MEMORANDUM

DATE: June 9, 2021

SUBJECT: PUDSP-20-005 – Falcon Meadows at Bent Grass (with EGP)
Fourth Submittal

PROPOSED DRAINAGE
MAP

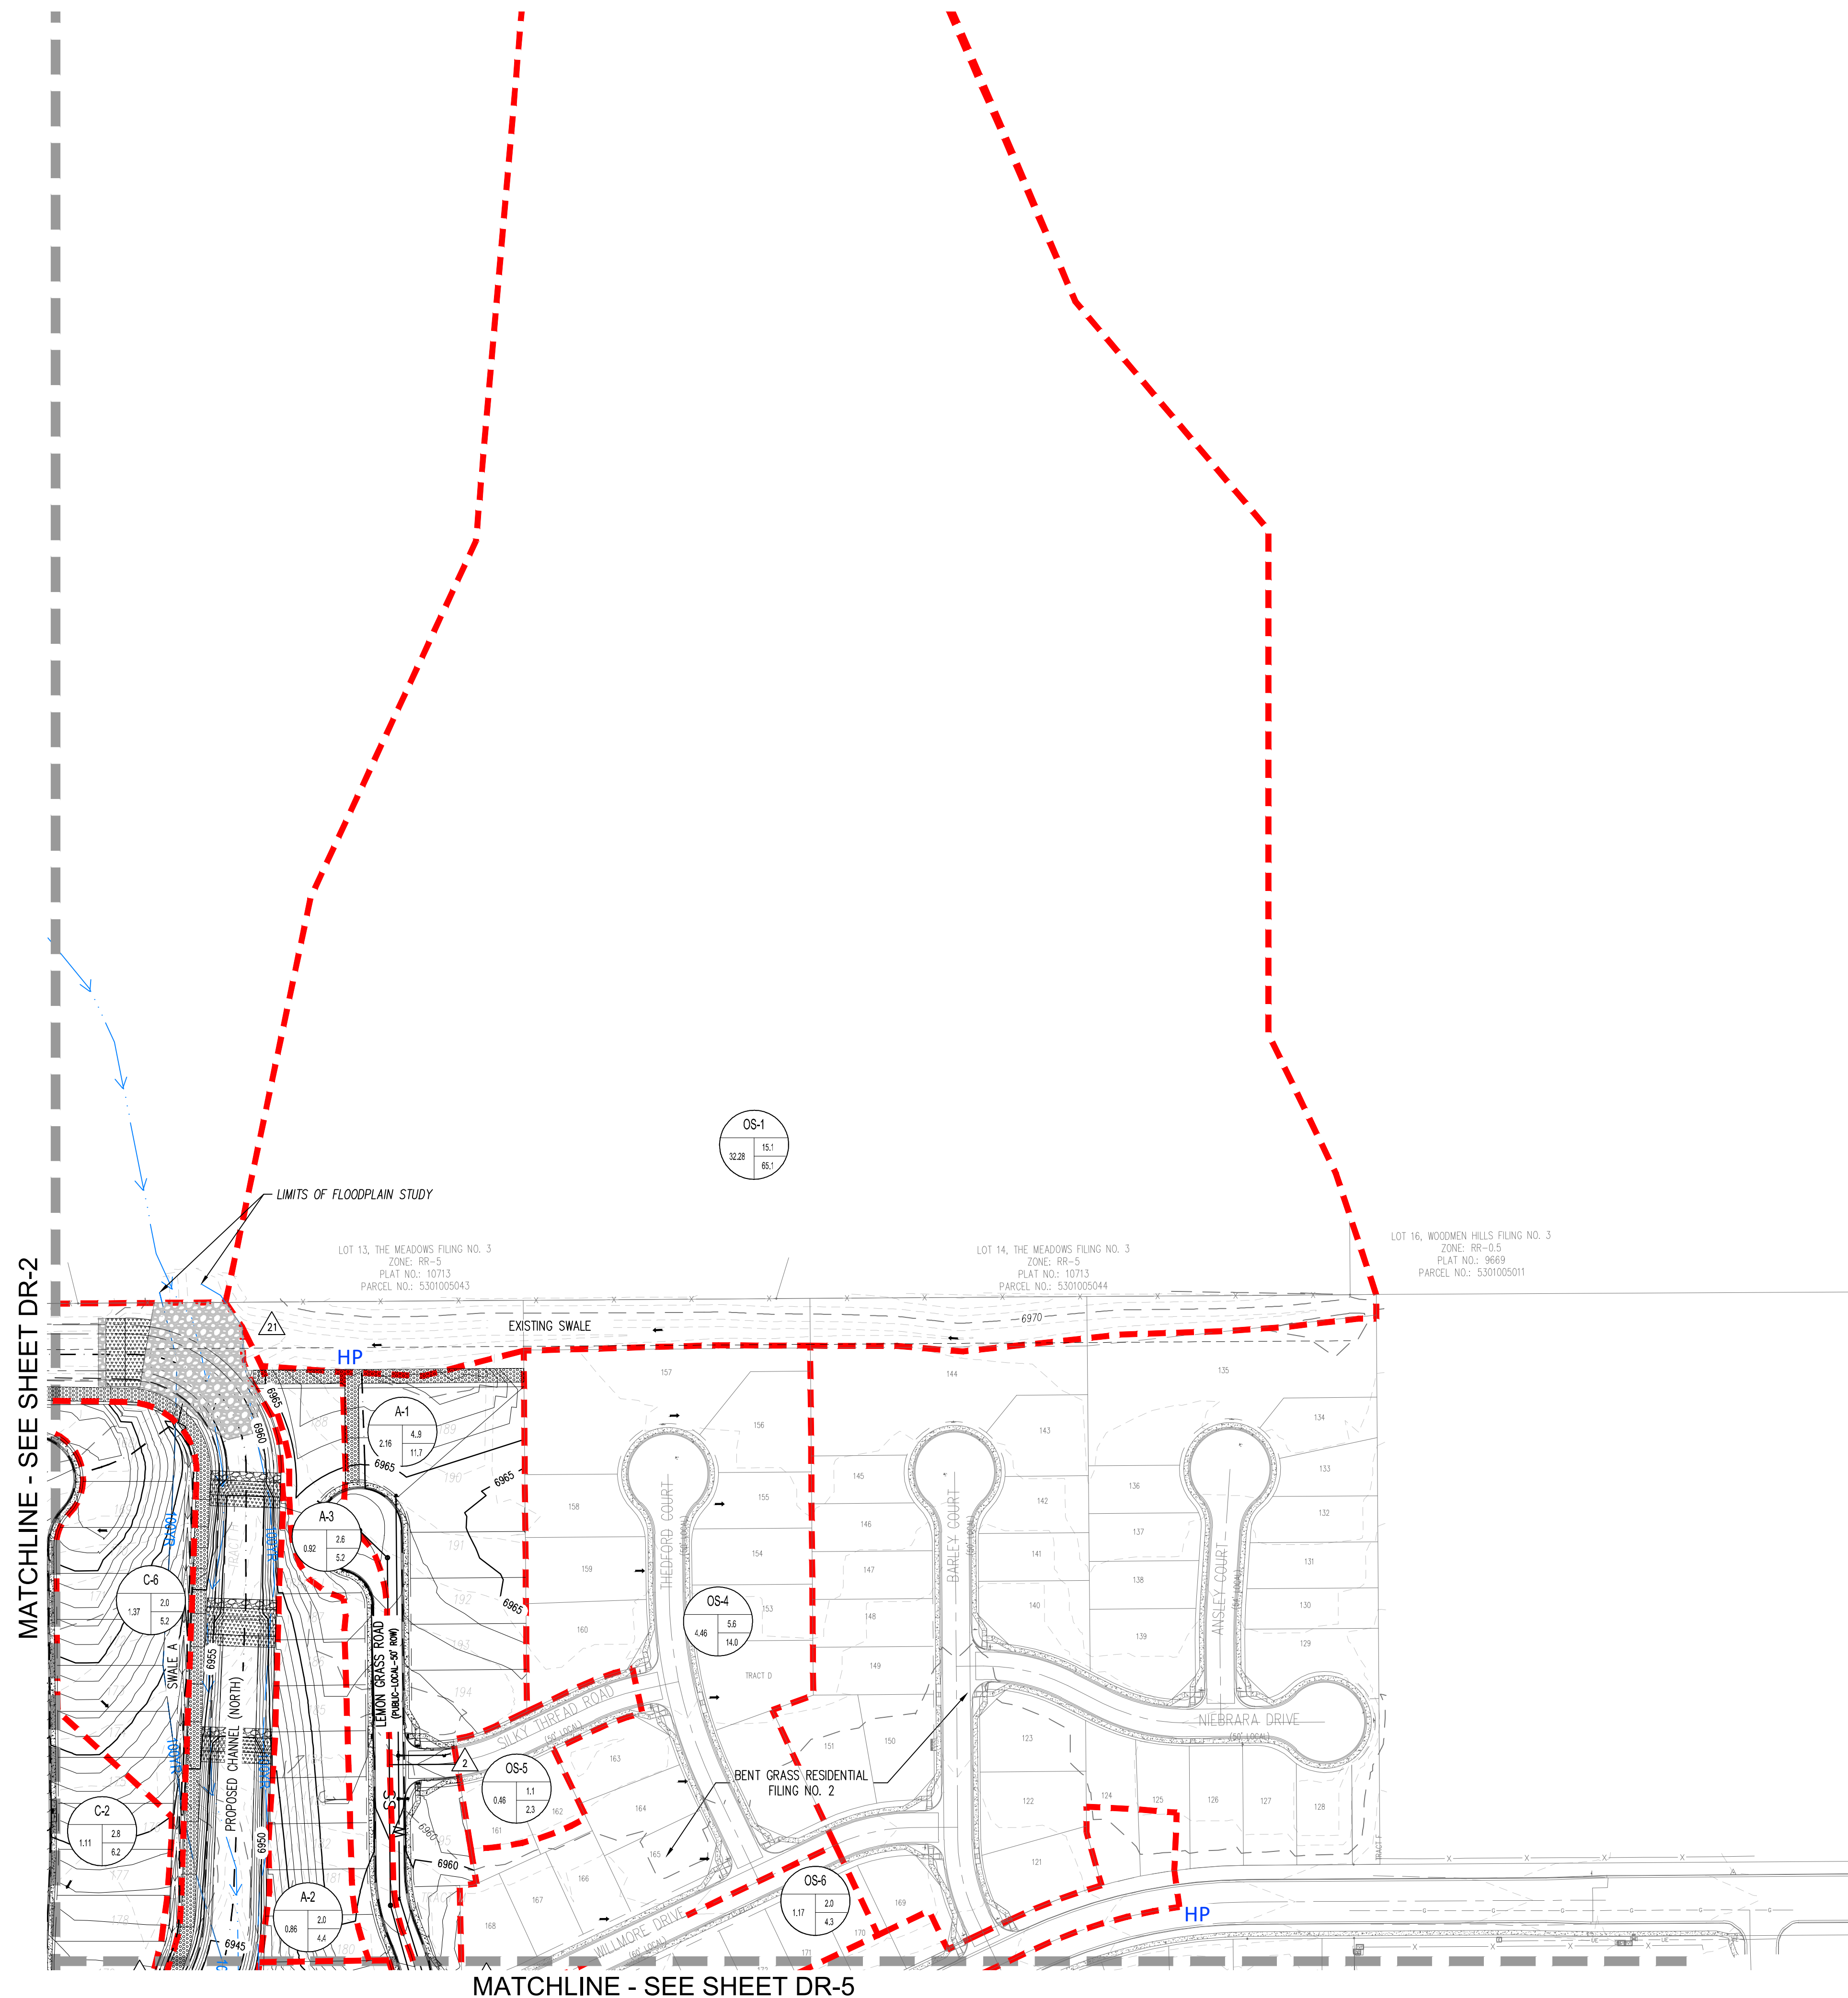
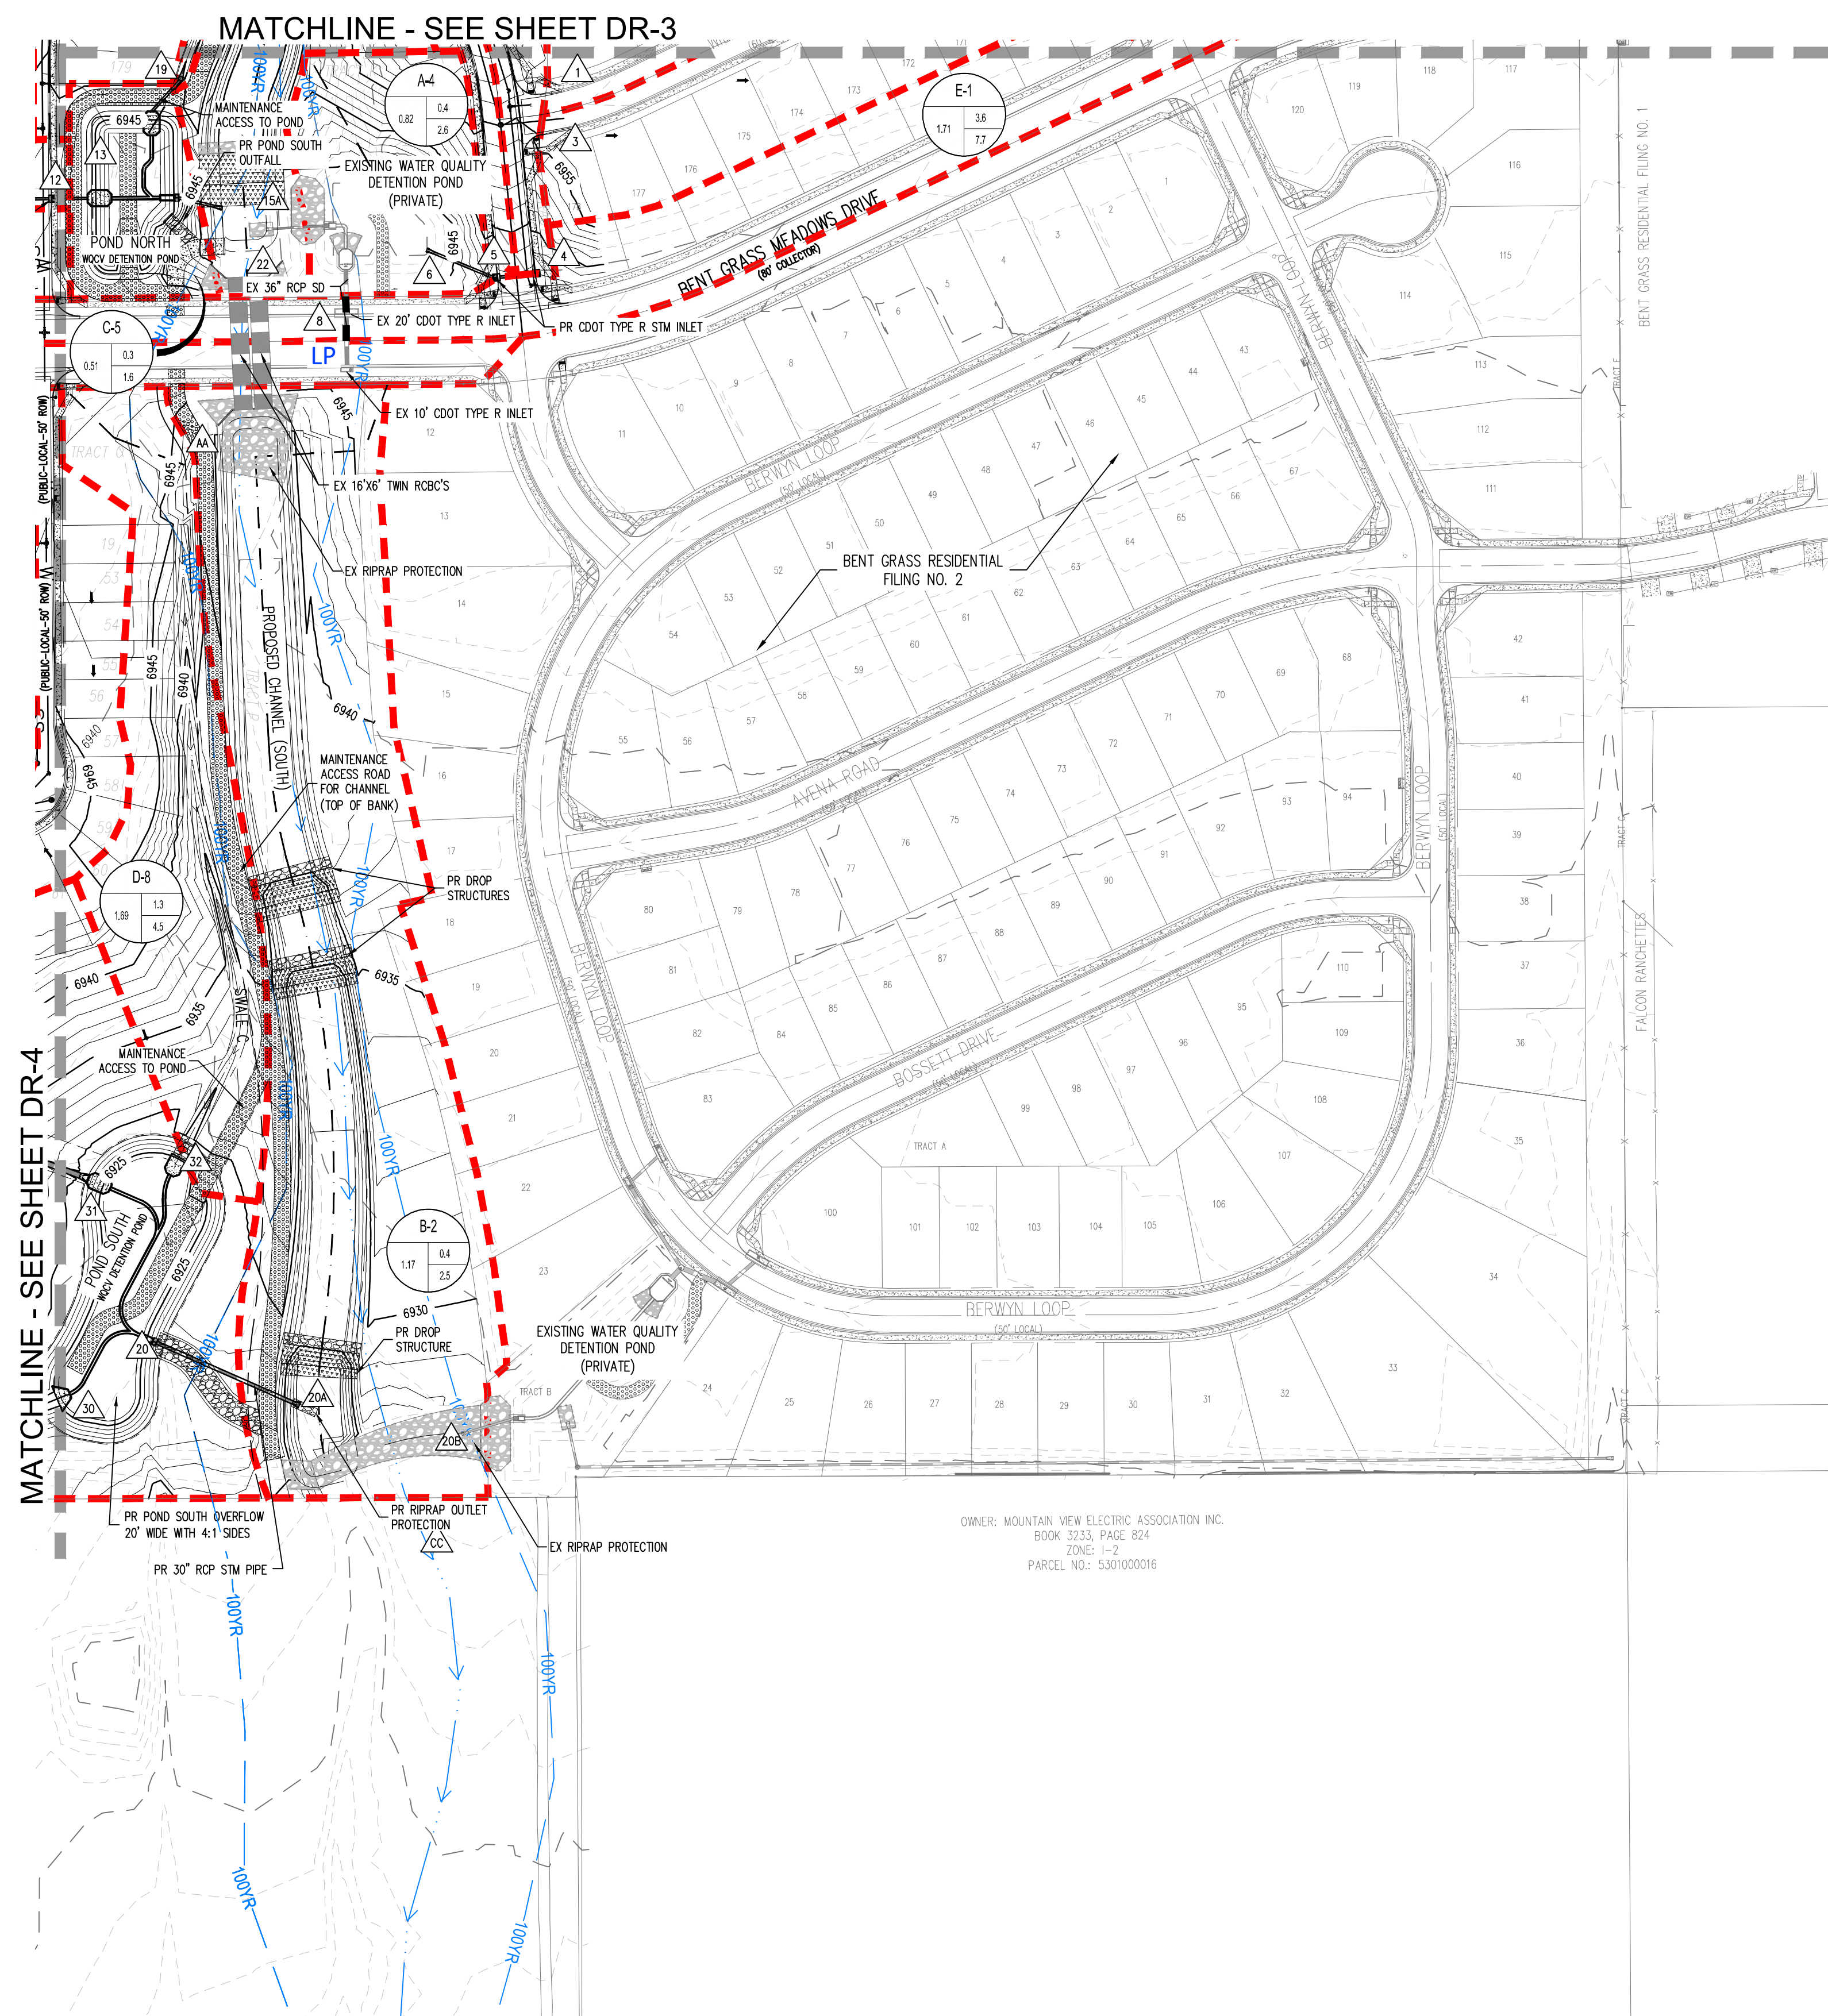
8. Address spillway design and FSD pond freeboard. Show the 100-year water surface elevations in the ponds and the channel. **Partially resolved;**
 - a. *Resolved.*

- b. The channel WSEs need to be shown. Provide a preliminary channel profile with the MDDP hydraulic modeling. *Unresolved.* **See MDDP redlines; update the PDR accordingly.**
Preliminary design of channel (Plan & Profile sheets, as shown in MDDP) which includes WSE have been included in report.

9. Resolved.
10. Resolved.
11. Provide channel and swale cross-sections and drop/check structure design on the plan. Provide a channel plan and profile. **Unresolved.**
At this time, no changes are being proposed from what is shown in the DBPS. Copies of the details from the DBPS have been included in the appendix, as also shown in the MDDP. Statement regarding design of channel, as included in MDDP, has also been added to this report
